Development Facilitation Team (DFT) – Review Comments

Project No: PR-2023-008085

Application Number: SI-2023-01465

Project Name: Spanish Walk Subdivision – 410 Camino Espanol

**LANDSCAPE PLAN
EPC**

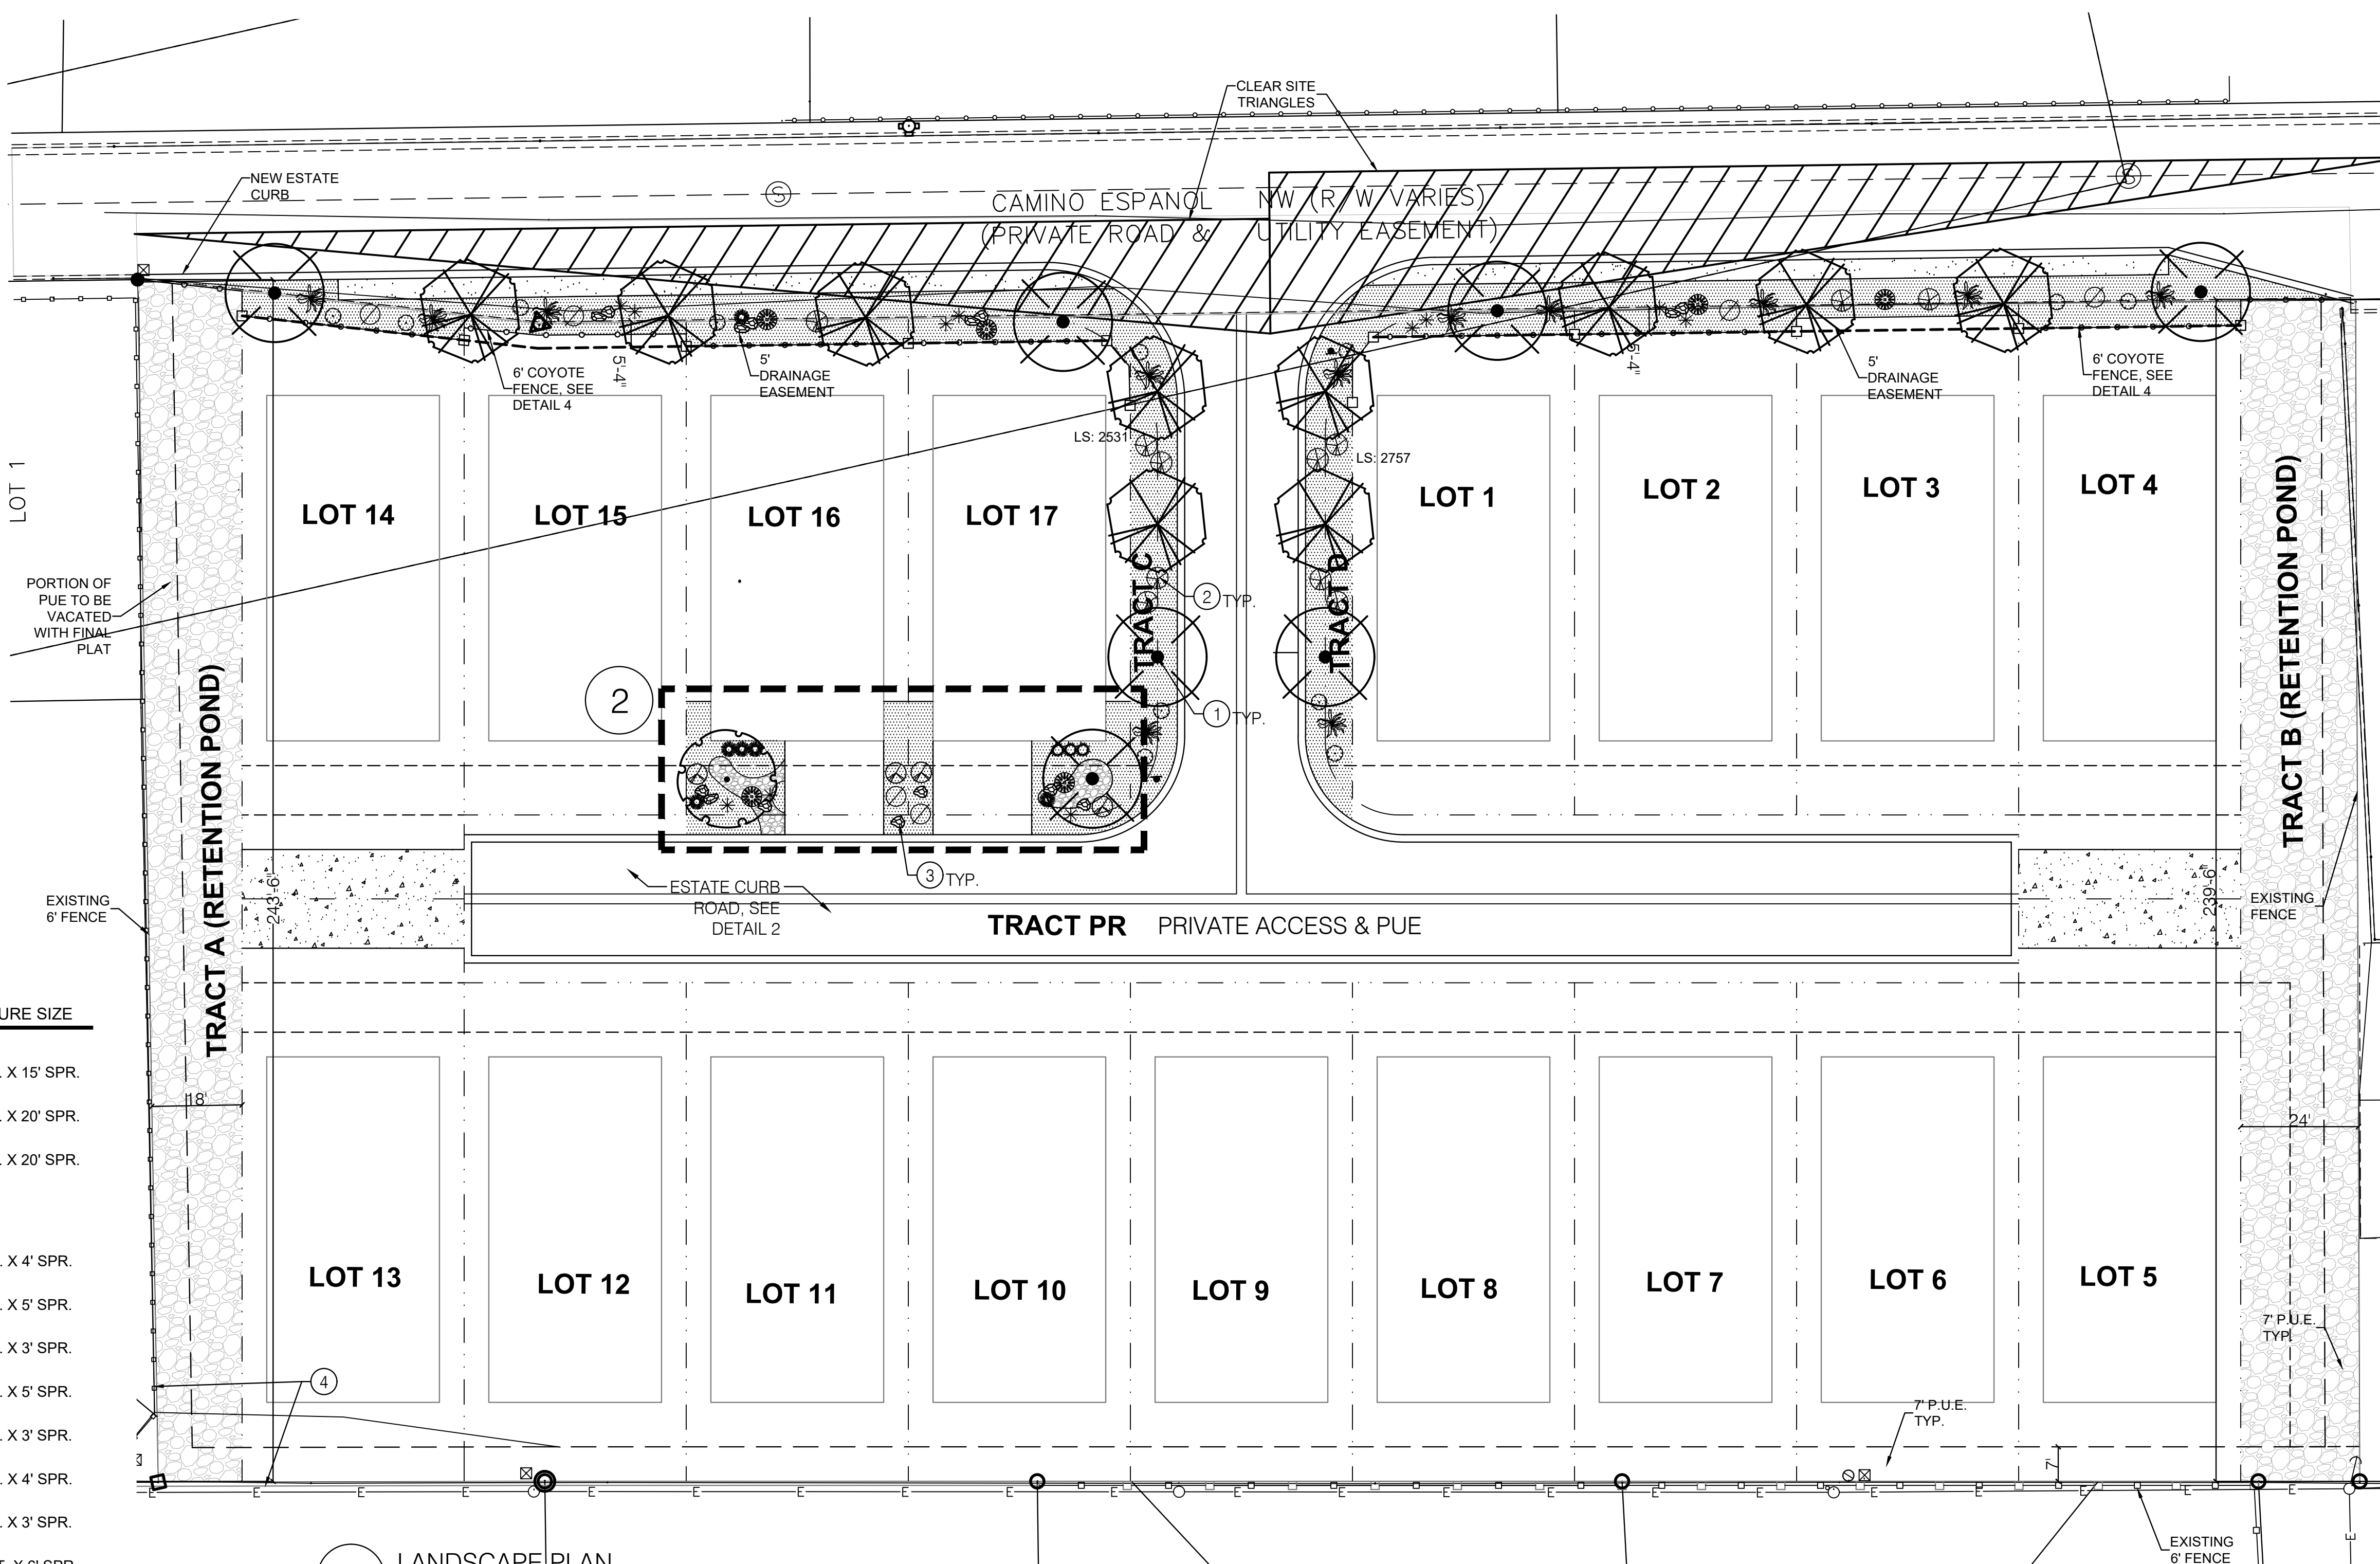
- B. *Landscaping calculations shall be shown.*
Proper landscaping calculations have been added to the landscaping Plan.
- C. *Square footage for all planting beds shall be indicated.*
While there are no landscape requirements for single family residential. They are providing an average of 565 SF of landscaping per lot on average.

- E. *Distances between street frontage trees within the subdivision shall be dimensioned.*
The Landscape Plan states "Street trees are based upon an average spacing of 40 feet O.C."

1 SIGN SCALE: N.T.S.

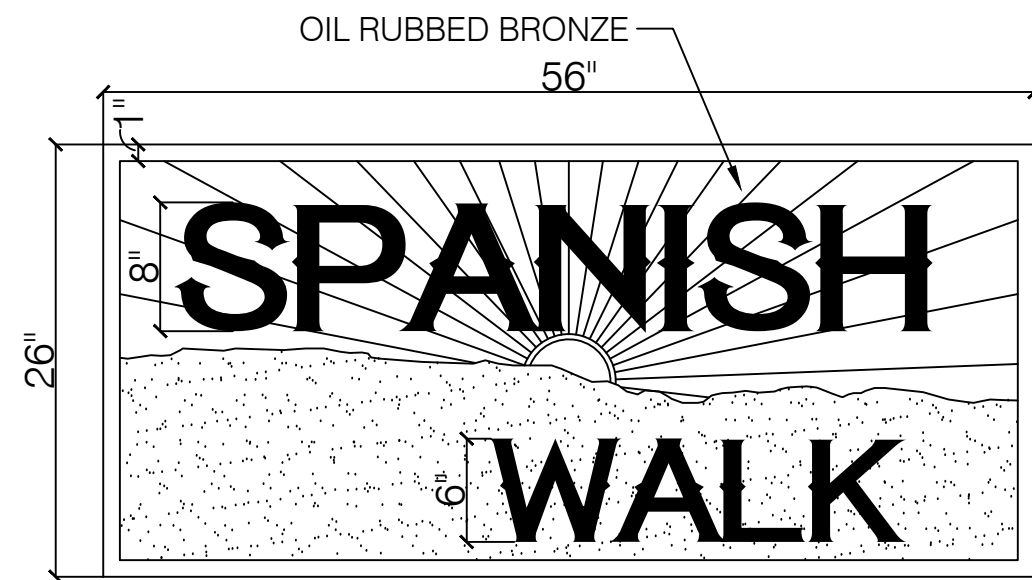
3. Proposed sign would not be allowed in a residential district, as per Table 5-12-1, which is referred to in IDO 5-12(F)(1), below. Again, if EPC Site Development Plan submitted, it is possible to pursue signage.

3. Proposed sign would not be allowed in a residential district, as per Table 5-12-1, which is referred to in IDO 5-12(F)(1), below. Again, if EPC Site Development Plan submitted, it is possible to pursue signage.

8. Signs:
- A. Signage area calculations shall be provided. *The sign detail is located on Sheet Planner was unable to locate these calculations. A500, Detail 1, and shows the sign dimensions and sign face area (10 s.f.)*

The signage was included in the approved Site Plan – EPC and is detailed on sheet A500 in the drawing set.

3 CRUSHER FINE PATH SCALE: N.T.S.

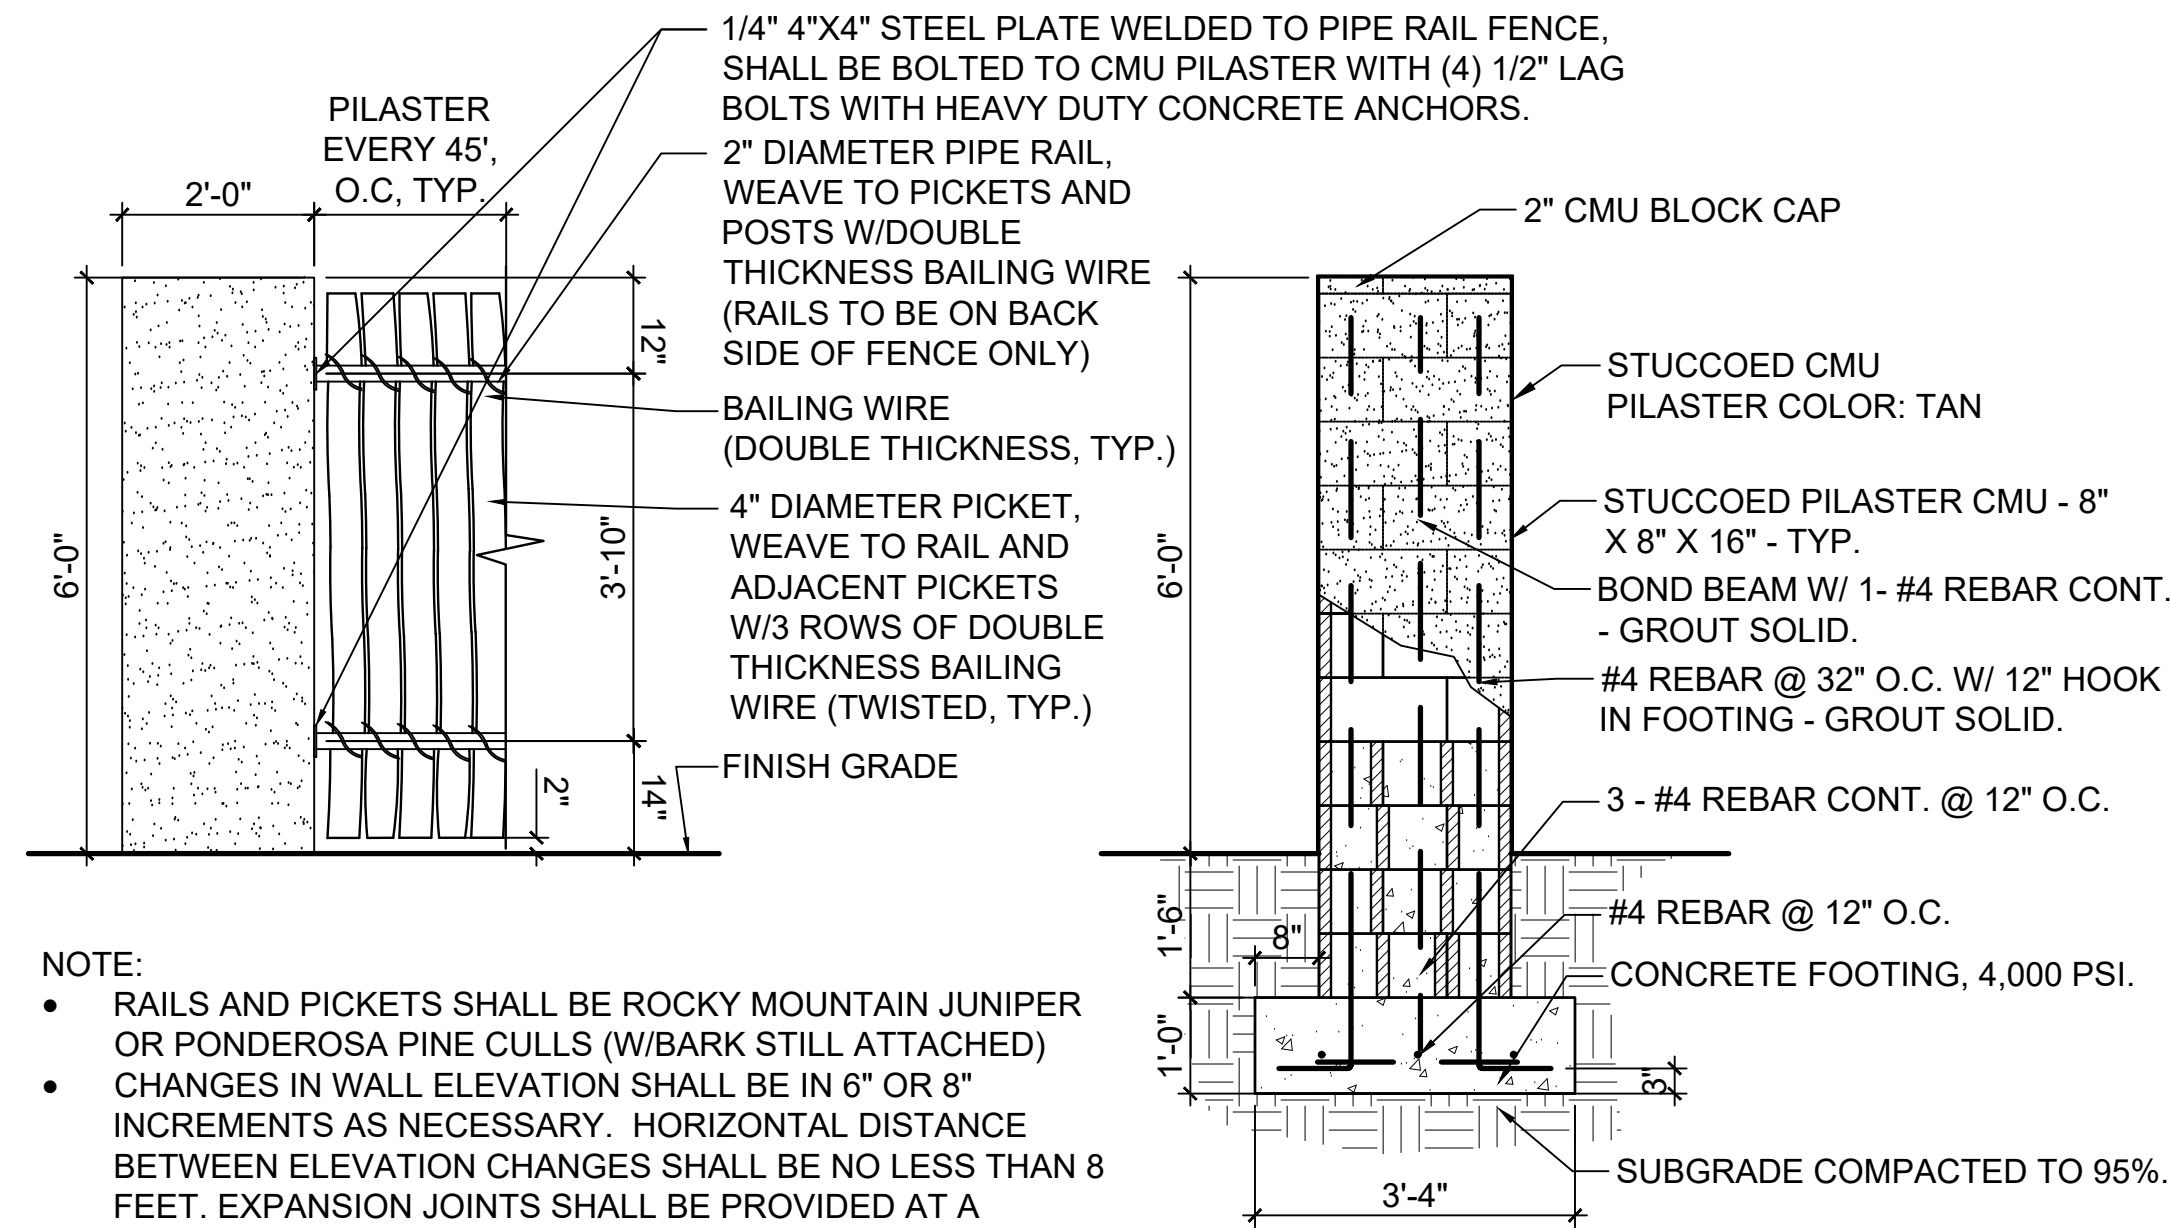
1. Transportation has an approved Conceptual TCL dated 7/24/2023.
2. As a reminder, it will be the responsibility of the property owners to maintain the compacted crusher fine trail to keep it suitable for ADA accessibility.

6. *Access and Connectivity:*
- A. *A crusher fine pedestrian pathway shall be provided along the perimeter of the subject site on the south side of Camino Español Rd. and shall meet DPM requirements.*
This condition has been satisfied.

4 COYOTE FENCE SCALE: 1/2" = 1'-0"

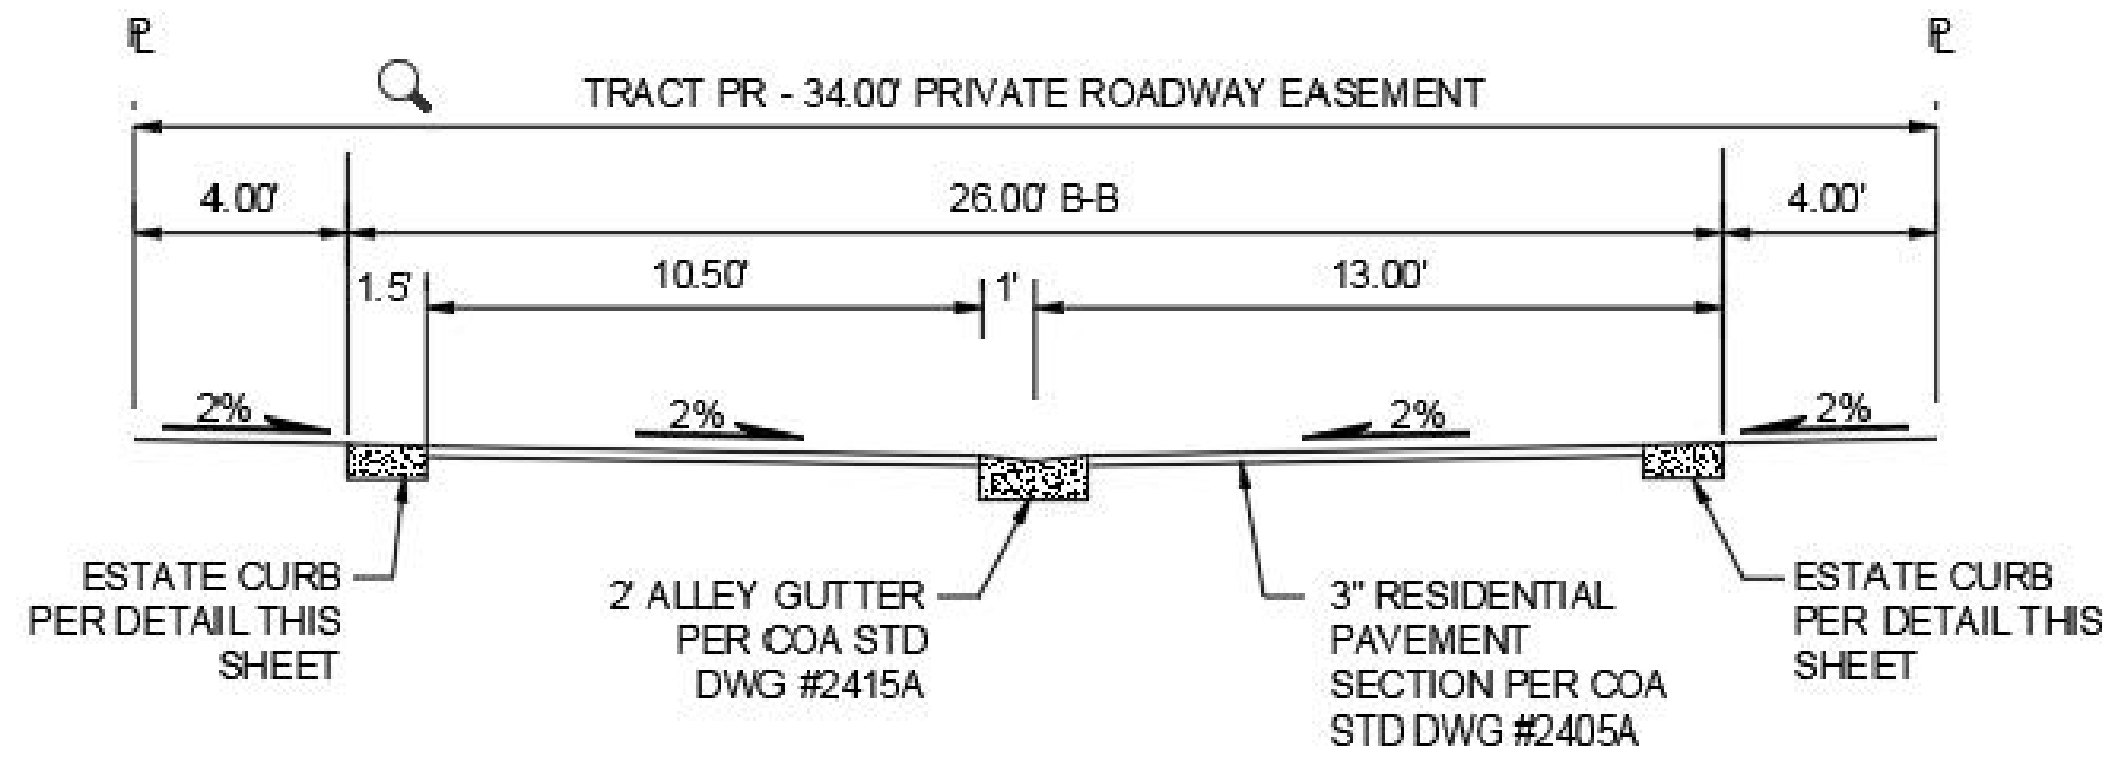
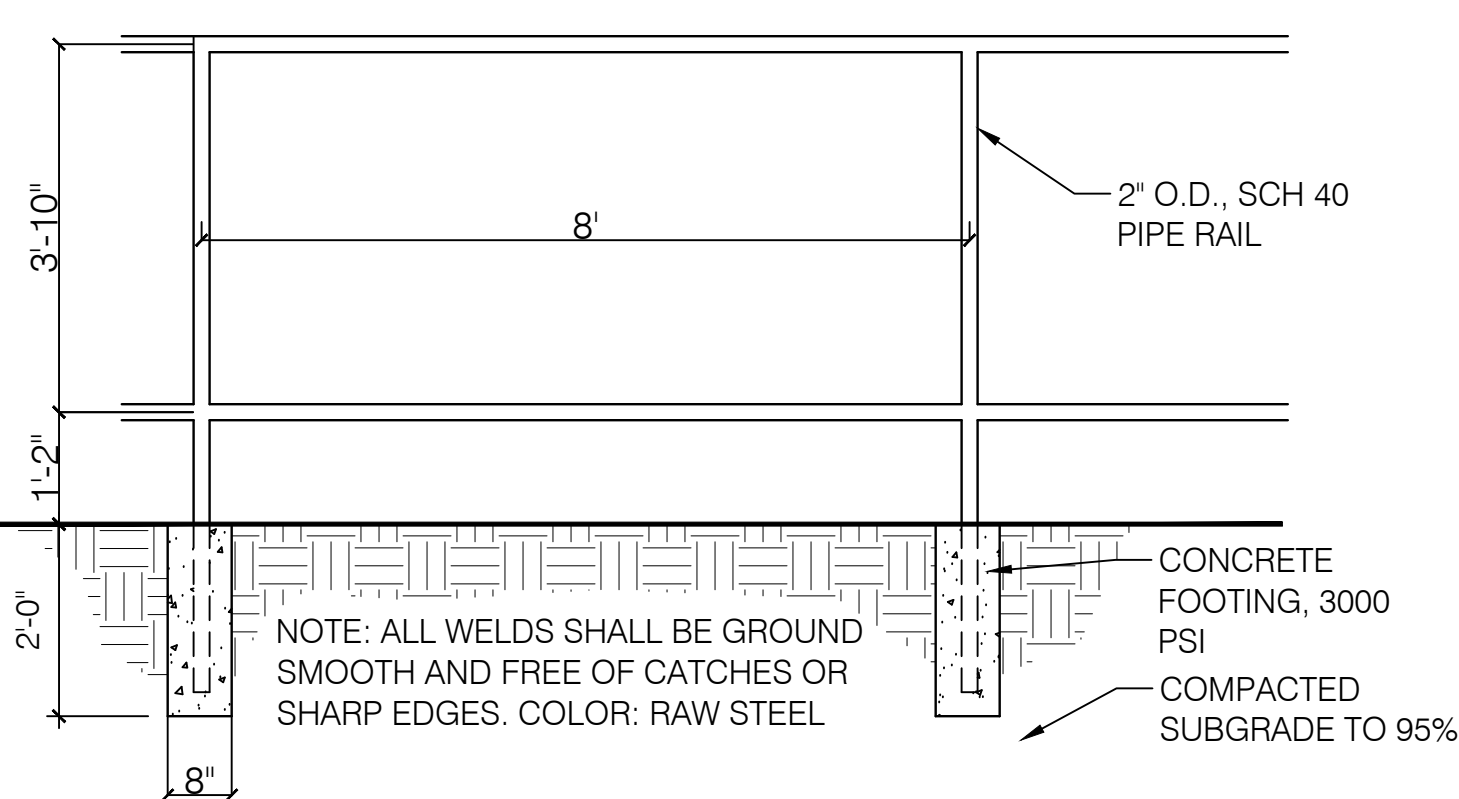
- B. ADA requirements shall be followed pursuant to 5-3(C)(1).
The crusher fine path is mentioned to be ADA-compliant
7. Walls and Fences:
- A. The perimeter wall along Camino Español NW shall match the existing design and character of other walls and fences in the neighborhood (ex. coyote fencing) to comply with the agreement made with the Camino Español HOA.
The perimeter wall along Camino Espanol is a coyote fence with either rocky mountain juniper or ponderosa pine (bark still attached). The coyote fence is indicated on the Site Plan and details are provided on the detail sheet.

- B. The site plan shall show the modified perimeter wall along Camino Español NW.
The coyote fence is shown on the Site Plan.
- C. All materials and colors shall be shown on the wall/fence detail.
materials and colors are shown on the wall/fence detail.

- D. The perimeter coyote fence shall provide articulation
The provided detail demonstrates that the coyote fence will be either rocky mountain juniper or ponderosa pine cull with bark still attached.
